Outline application with all matters reserved for 22 No. new dwellings consisting of 2 No. 1 bed dwellings, 18 No. 2 bed dwellings & 2 No. 3 bed dwellings.

26 Burnham Avenue Bognor Regis

Thank you for your internet representation made on 27th April 2019 which has been recorded as '**an objection**' with the comments as follows:

Streetscape (Proposed) 1:100
0 2.5 5.0 M

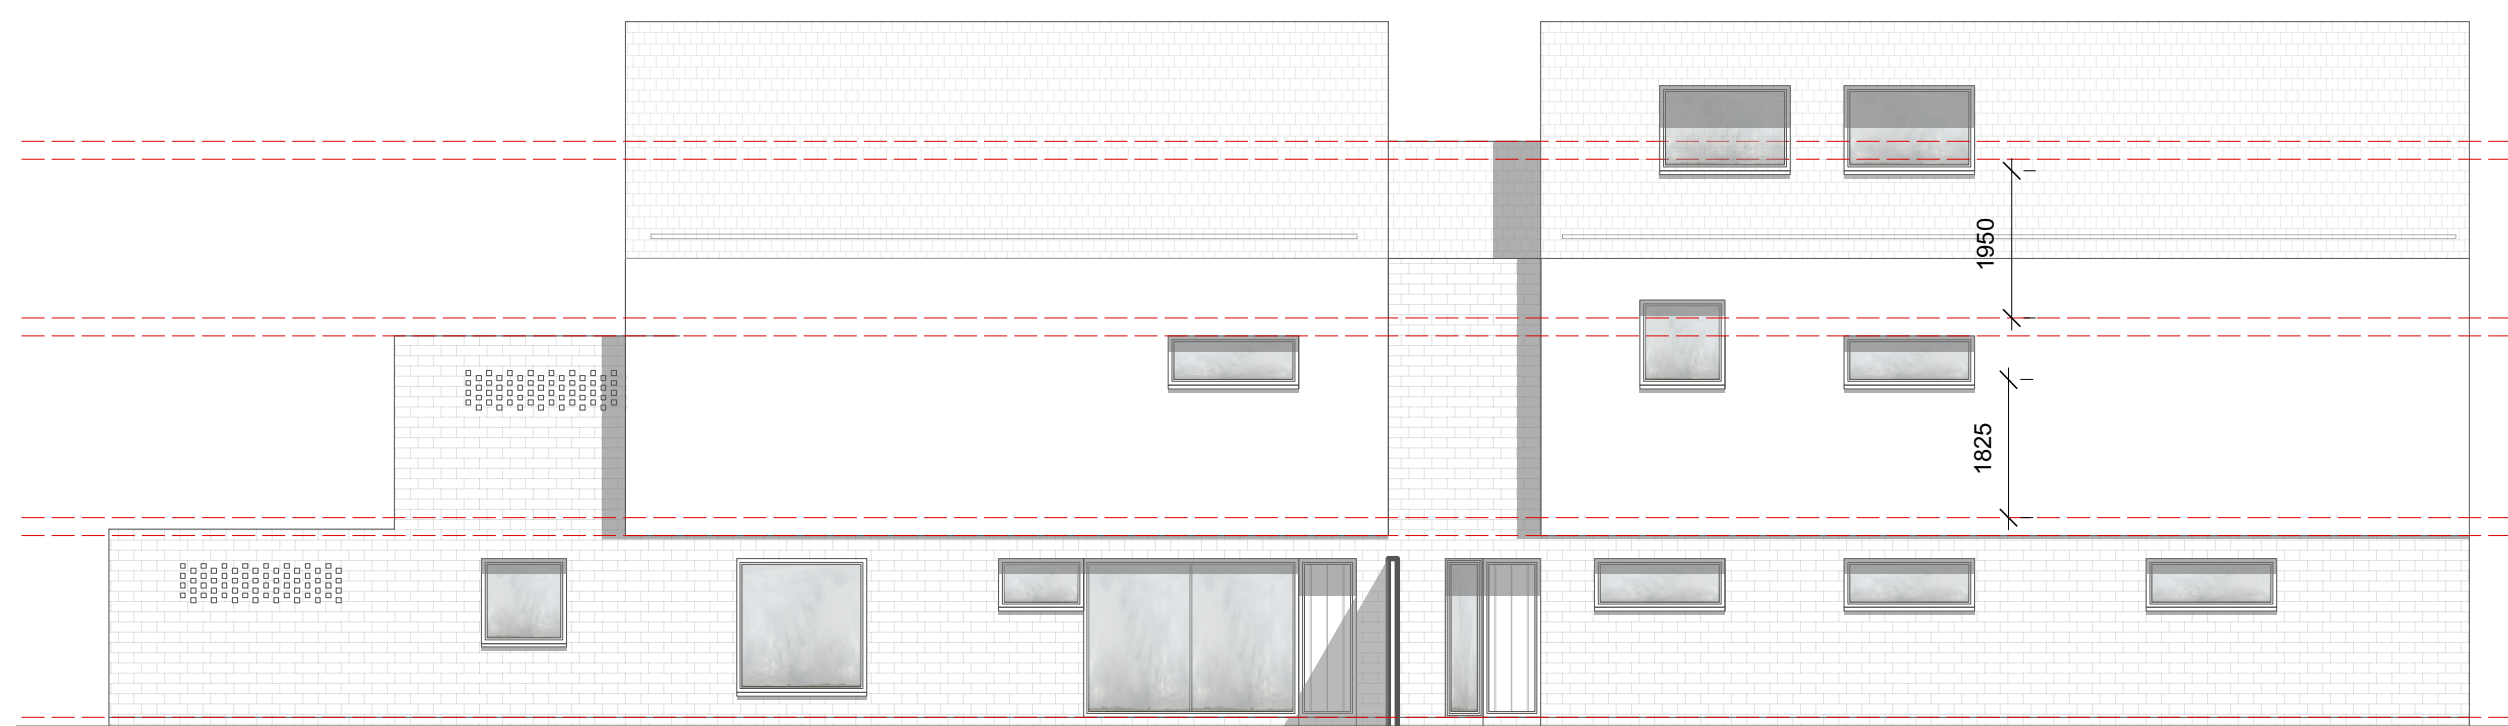
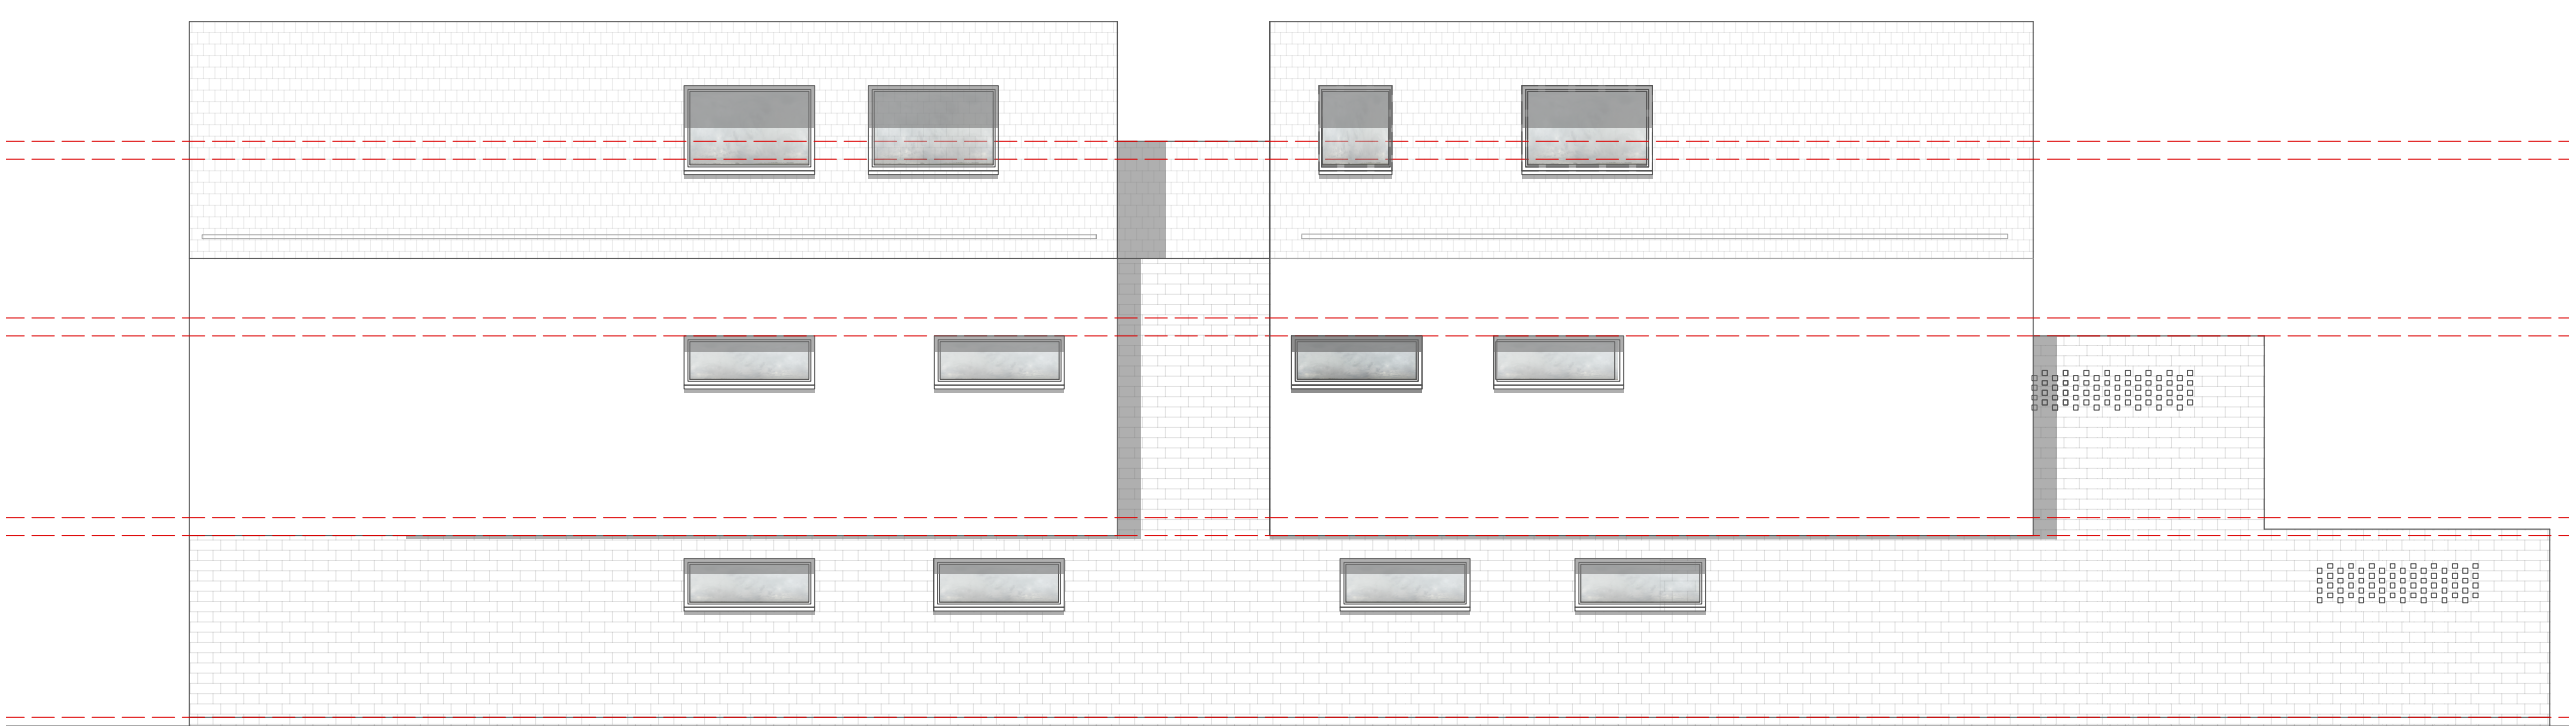
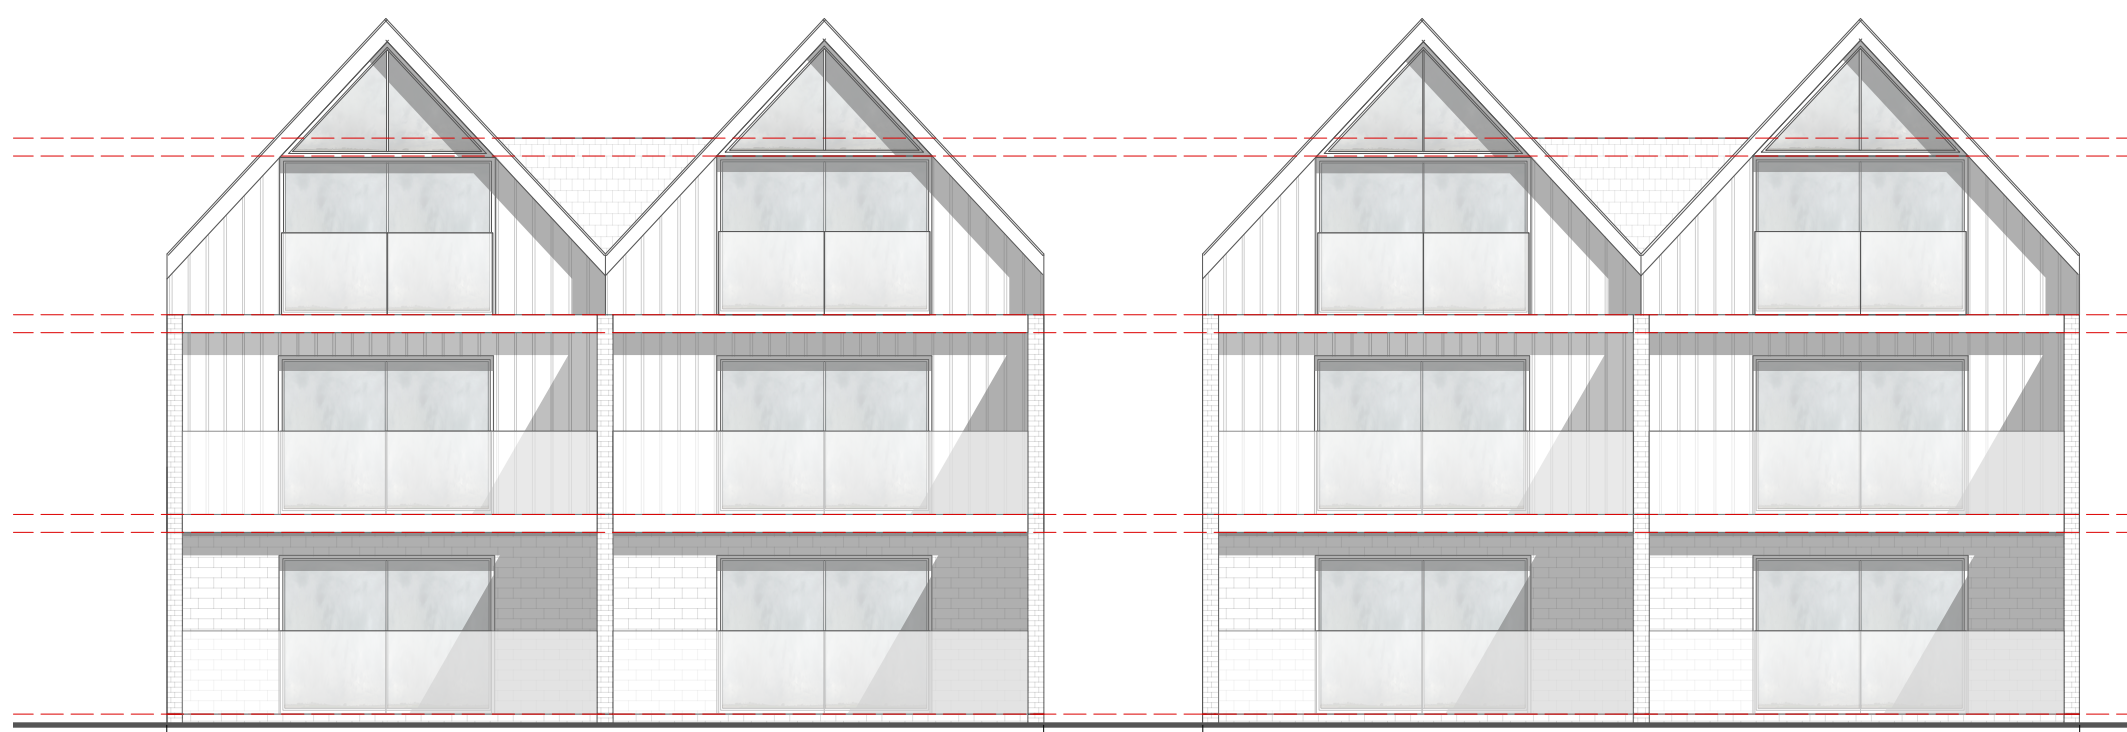
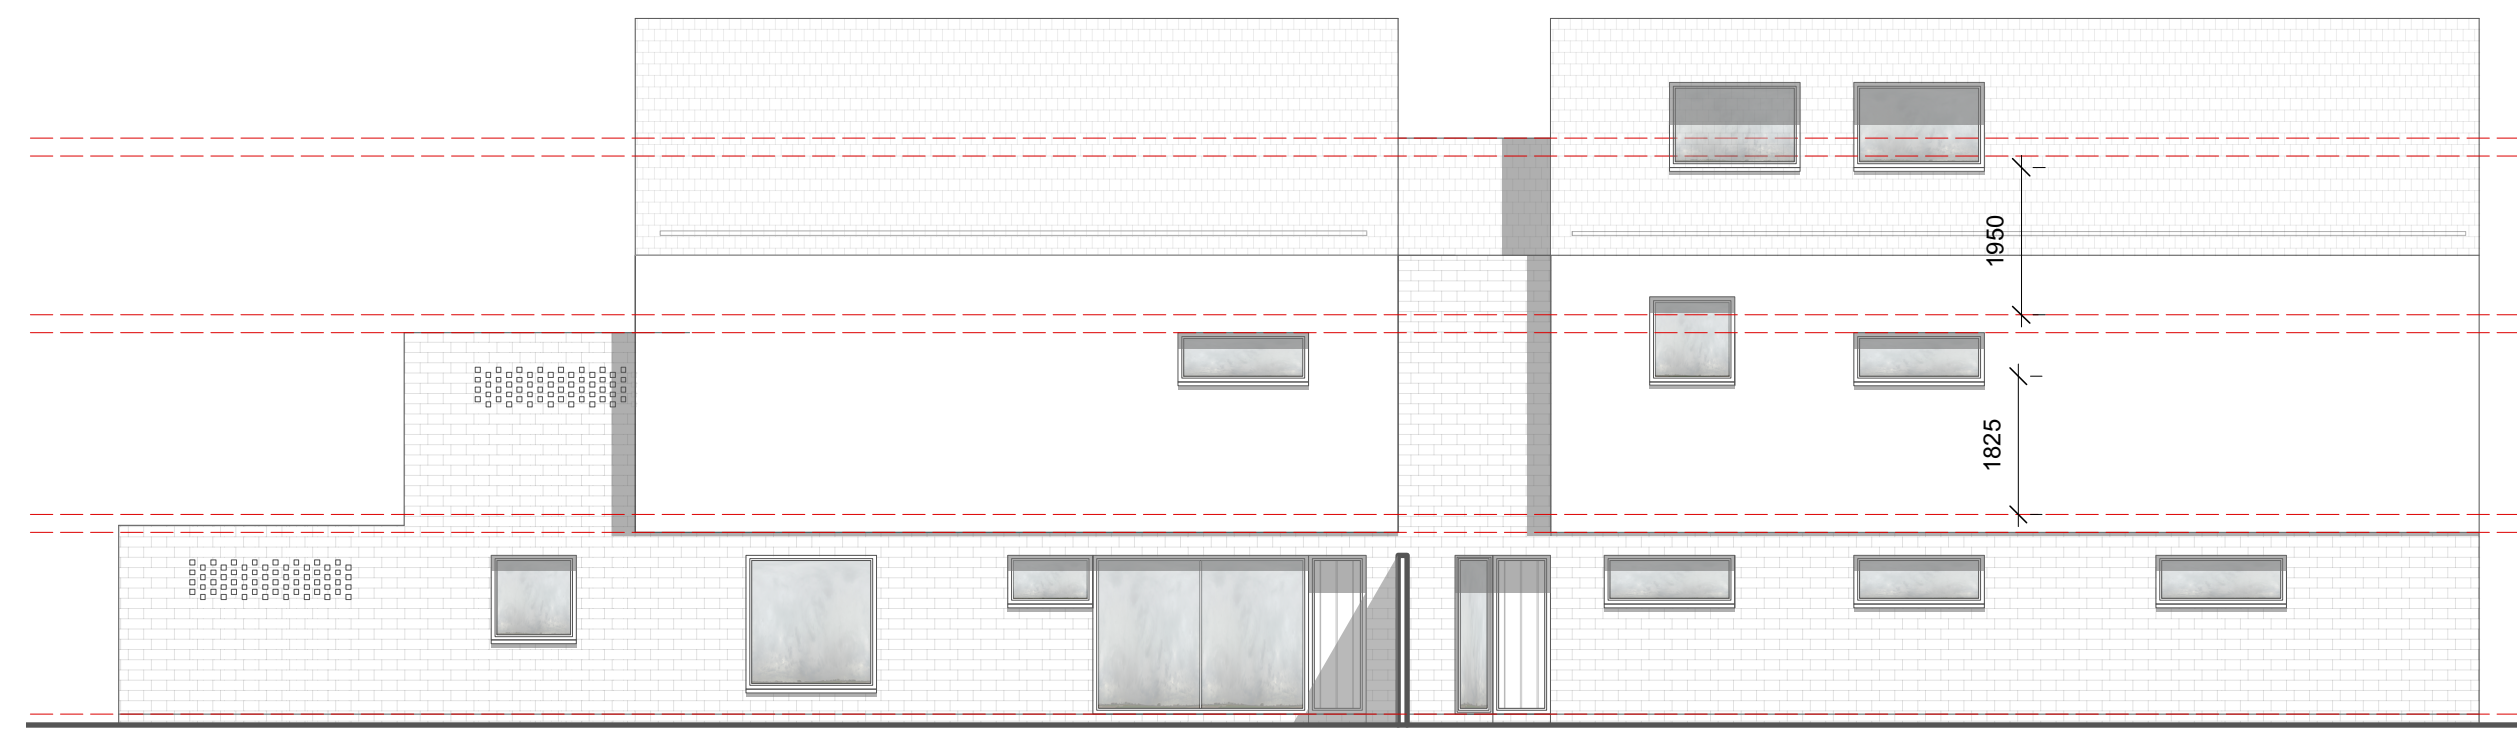
This proposed development is completely unsuitable for the area for the following reasons: It does not reflect the design or character of the existing houses in the area or the house it would replace.

Environmentally it will be more damaging to the area than the current building as it covers more ground with hard-standing, thus putting more pressure on the drainage system, rather than the current benefits of an area that naturally absorbs rainfall. The density of occupants will also contribute to increased service demands that impact environmentally e.g. rubbish and transport needs.

The development has not allowed for any parking on site, instead expecting the surrounding roads, which are already at capacity to absorb the considerable number of vehicles inevitably attached to the occupants.
